CITY OF ALBUQUERQUE

PLANNING DEPARTMENT – Development Review Services

June 17, 2016

RE: **Desert Hills Modernization (File: G11D051 – previously G11D048)**
5200 C Sequoia Rd. NW (new RTC bldg)
Grading and Drainage Plans, Eng. Stamp Date 6-20-2014
Engineer's Certification Date 6-14-16

C4.1

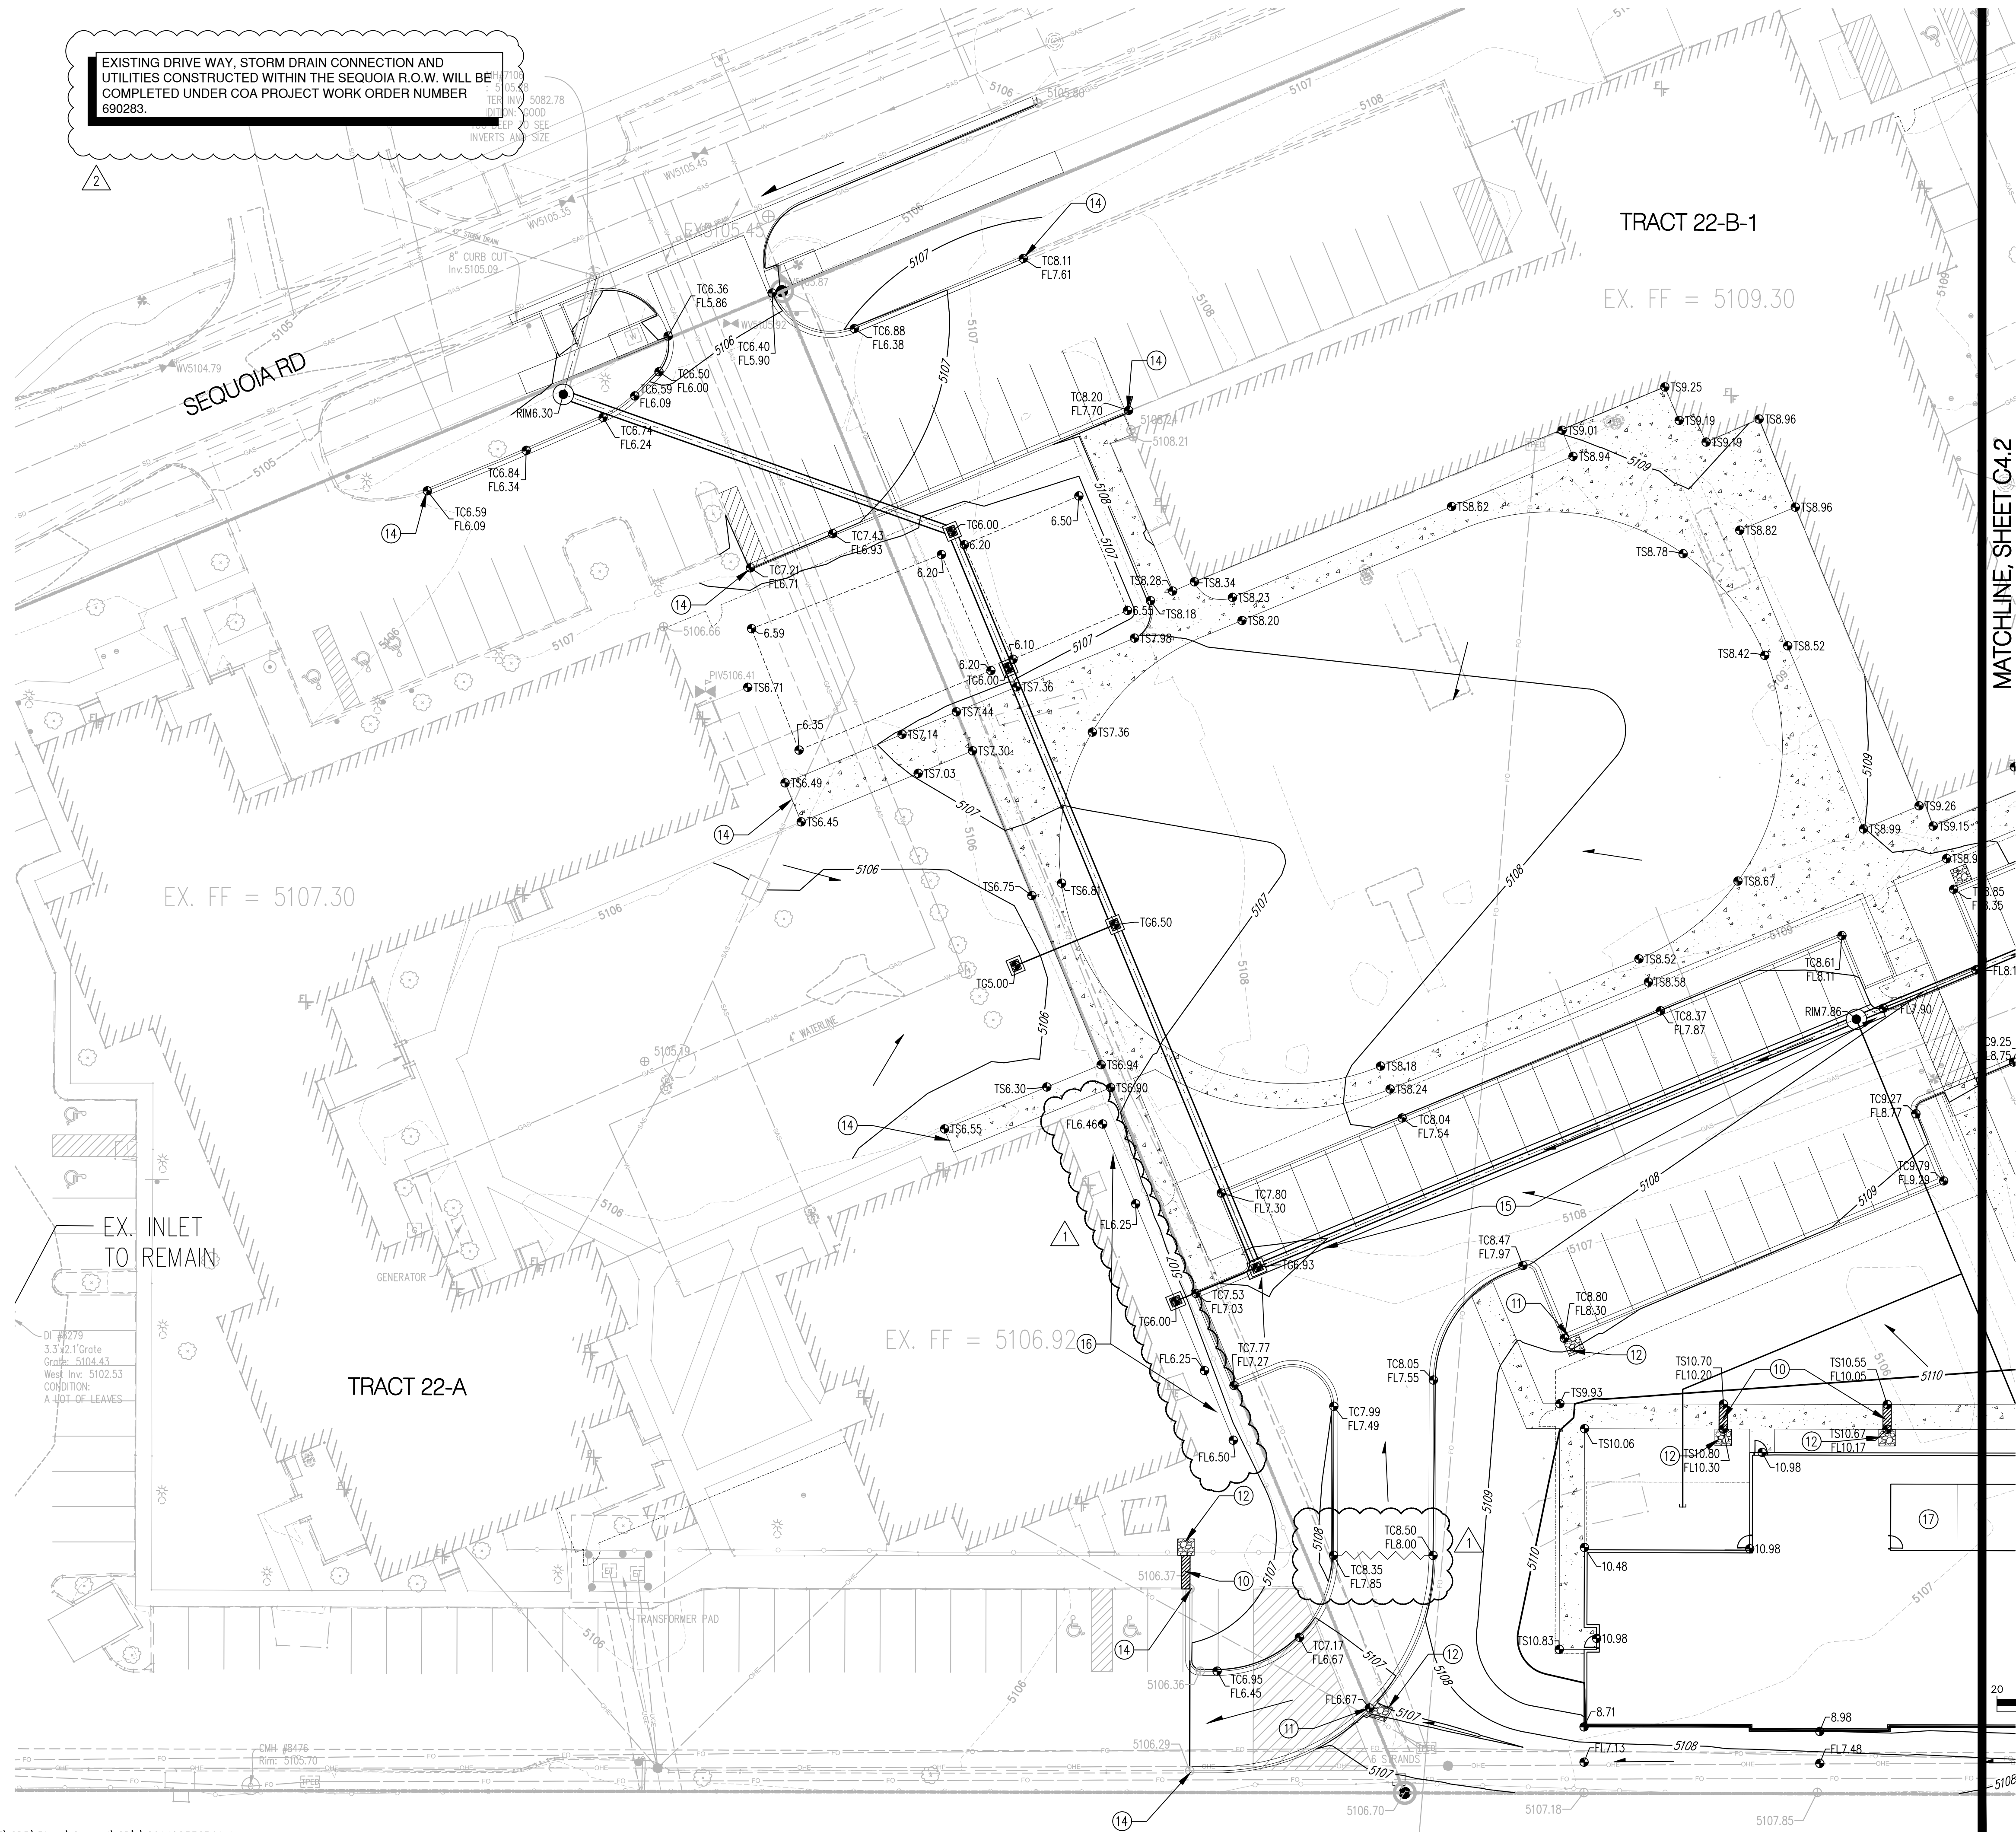
After a site visit yesterday, it was noted that landscaping gravel and crusher fines were dropping into the inlets. The manager stated that cobble was not acceptable for use in this facility as the rocks can be thrown. A method to prevent the crusher fines and gravel from entering the inlets needs to be devised. (see attached photos)
